**Tweed Valley Hospital Multi-Deck Carpark
SSD3 AMENDMENT REGISTER****DCR-SSD3**

We issue herewith the list of changes made on the drawings as sent in the nominate transmissions.

Transmittal Date 16.09.2022

REV	DESCRIPTION	AUTH	CHK	DATE
1	ISSUED FOR SSD			06/09/19
2	ISSUED FOR SSD2	CN	AB	15/12/21
3	ISSUED FOR SSD2	AB	AB	15/02/22
4	ISSUED FOR SSD2	AB	AB	21/02/22
5	SSD3 FOR REVIEW	AB	AB	24/06/22
6	ISSUED FOR SSD3	LC	AB	30/06/22
7	ISSUED FOR SSD3	LC	AB	20/07/22
8	ISSUED FOR SSD3	LC	AB	16/09/22

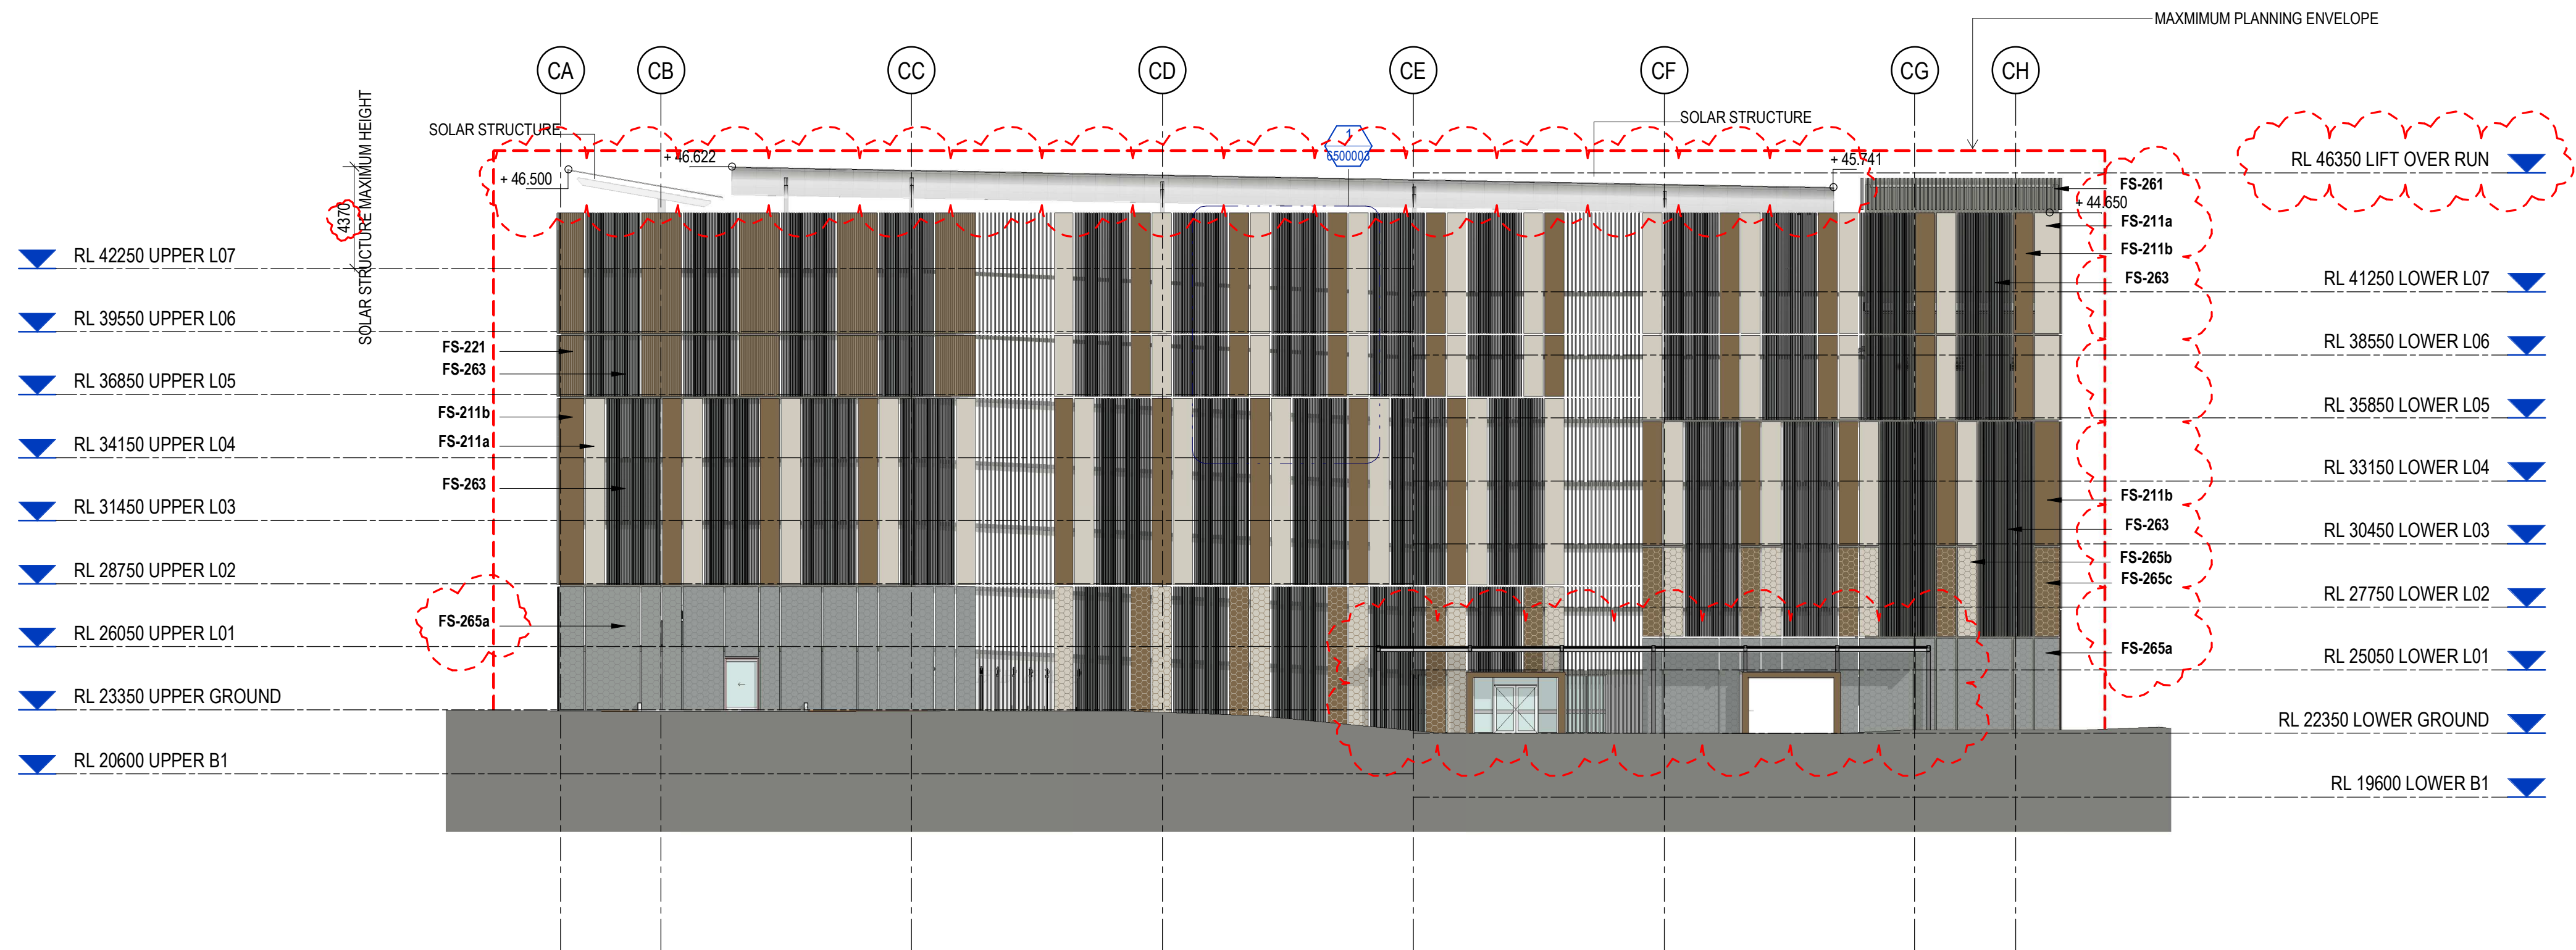
3	Roof Awning shown to lift lobby - part of design development	
			4	Turning bay shown along Grid CC / C4 and C7 as per Traffic Engineers advice, to become parking bays in future construction stage of Levels 6 and 7	
			5	Accessible parking bay clear zone defined	
			6	Drainage Wastes amended from Circular to square type as part of design development	
MDD-AR-SKE-MCP-2007001	FLOOR PLAN LEVEL 7	4	1	General Arrangement of Solar Structures developed as part of detailed design as per supplier advice, parking bays adjusted where required to maintain compliance	
MDD-AR-SKE-MCP-2500001	LIFT OVERUN - LVL7 / ROOF PLAN	8	1	General Arrangement and orientation of Solar Structures developed as part of detailed design as per supplier advice	
			2	Lift Over Run RL amended to suit Vertical Transport Manufacturer Requirements	
MDD-AR-SKE-MCP-4000001	ELEVATIONS	7	1	Façade Types amended to meet requirements of FEBQ and FRNSW

MDD-AR-SKE-MCP-4000002		7	2	Façade Types Legend Amended to reflect proposed materials. Finish Codes deleted, refer to finishes schedule for selections	
			3	East Elevation Covered Walkway Extended and Café Tenancy Entry Shown

DRAWING TITLE
SECTIONS

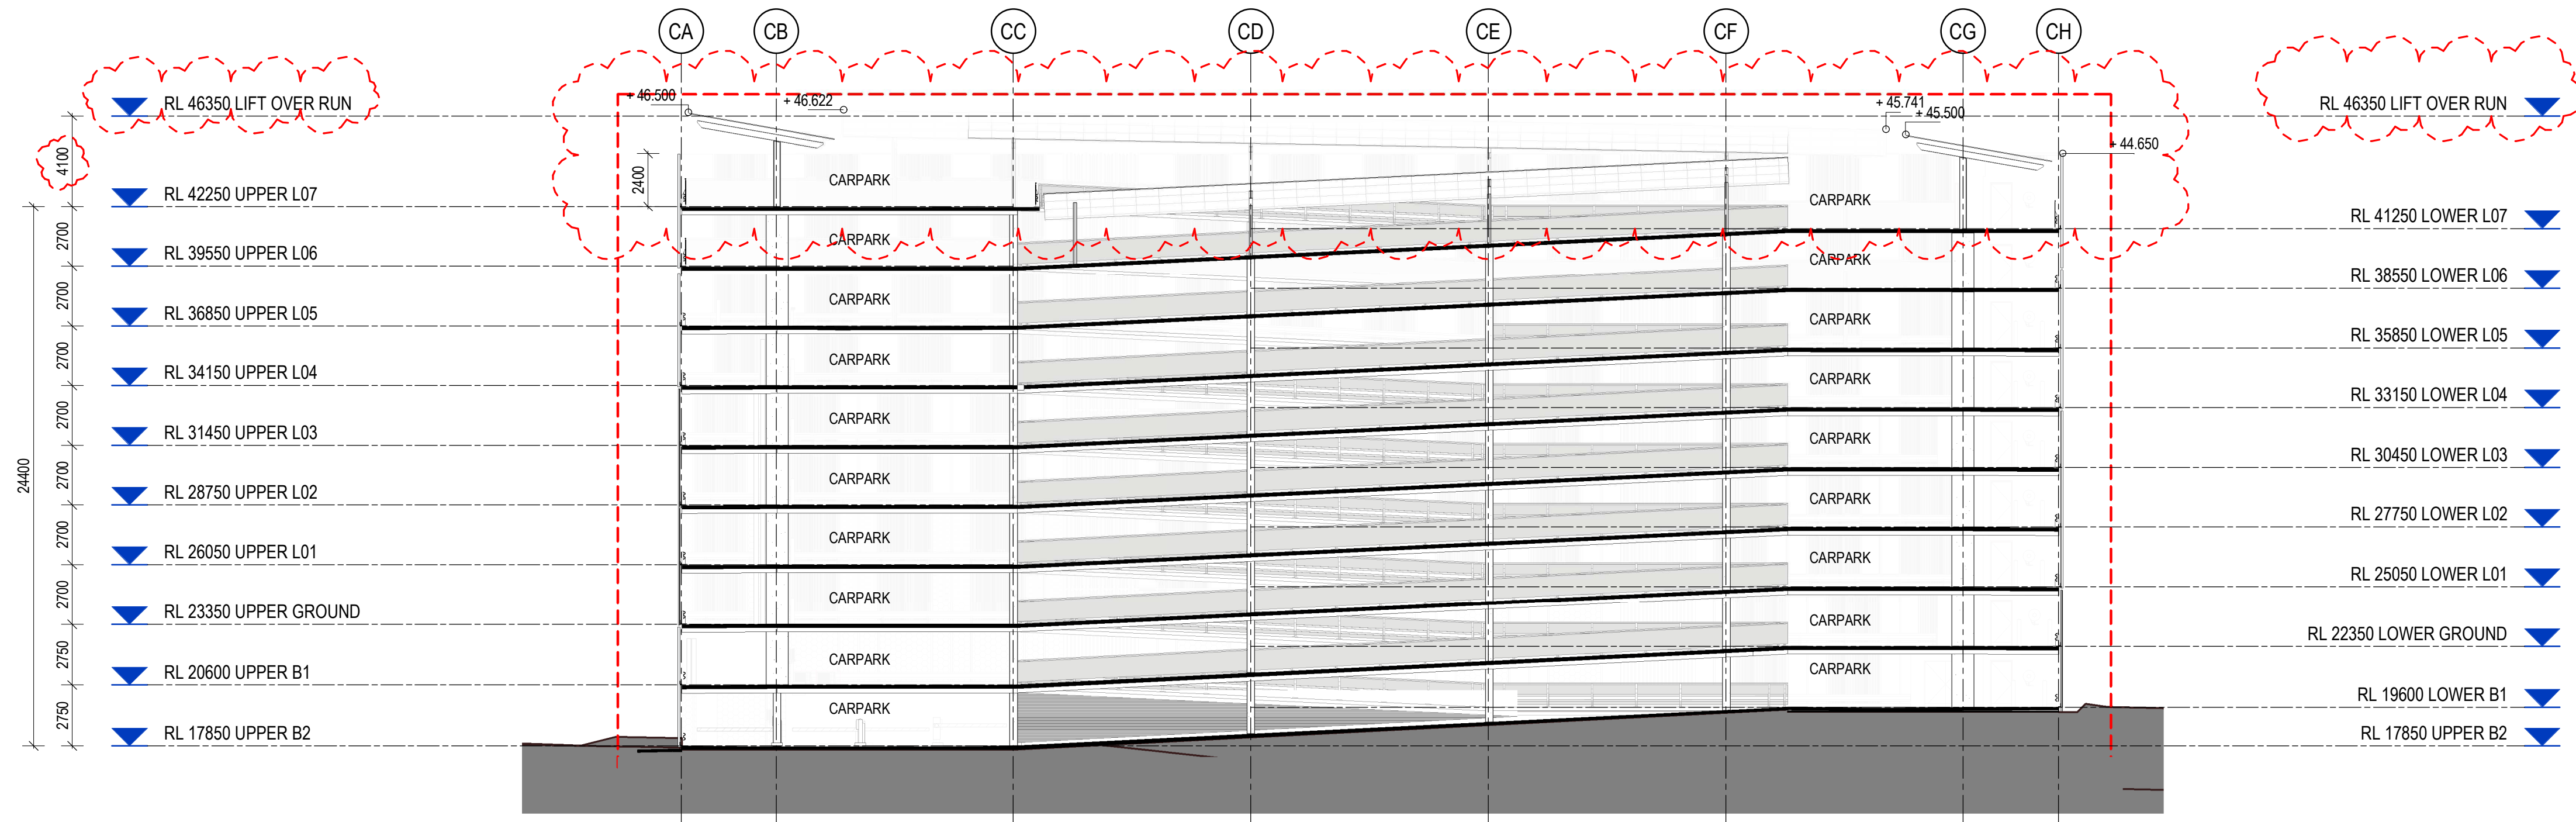
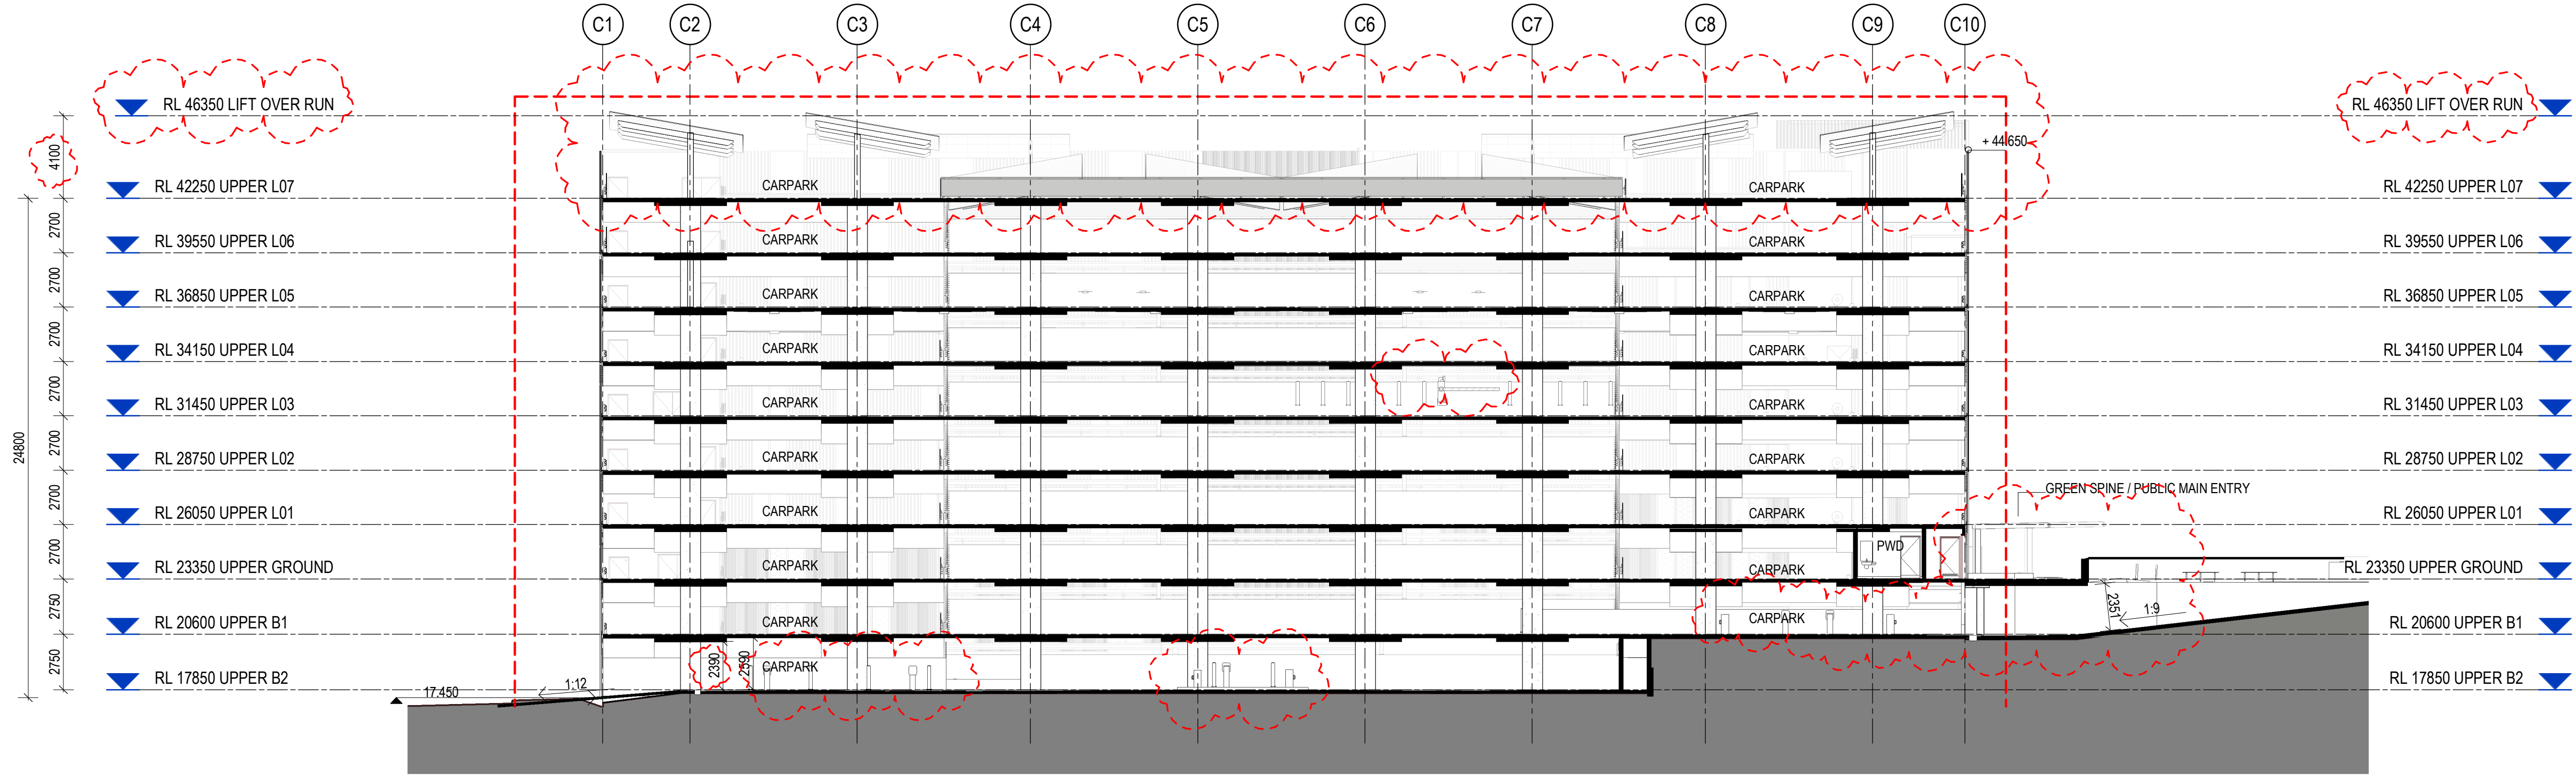
Doc. No.	Document Title	Doc. Rev. #	Doc. Change #	Doc. Change	Notes
			4	Lift Over Run amended to suit Vertical Transport Manufacturer Requirements	
			5	General Arrangement and orientation of Solar Structures developed as part of detailed design as per supplier advice	
MDD-AR-SKE-MCP-5000001	SECTIONS	5	1	Lift Over Run amended to suit Vertical Transport Manufacturer Requirements	
			2	General Arrangement and orientation of Solar Structures developed as part of detailed design as per supplier advice	
			3	Public Vehicle Entry and Exits revised as per Traffic Engineers recommendations for compliant sweep paths	
			4	Staff Parking overflow arrangement amended as part of design development	
MDD-AR-SKE-MCP-5000002	SECTIONS	7	1	Lift Over Run amended to suit Vertical Transport Manufacturer Requirements	
			2	General Arrangement and orientation of Solar Structures developed as part of detailed design as per supplier advice
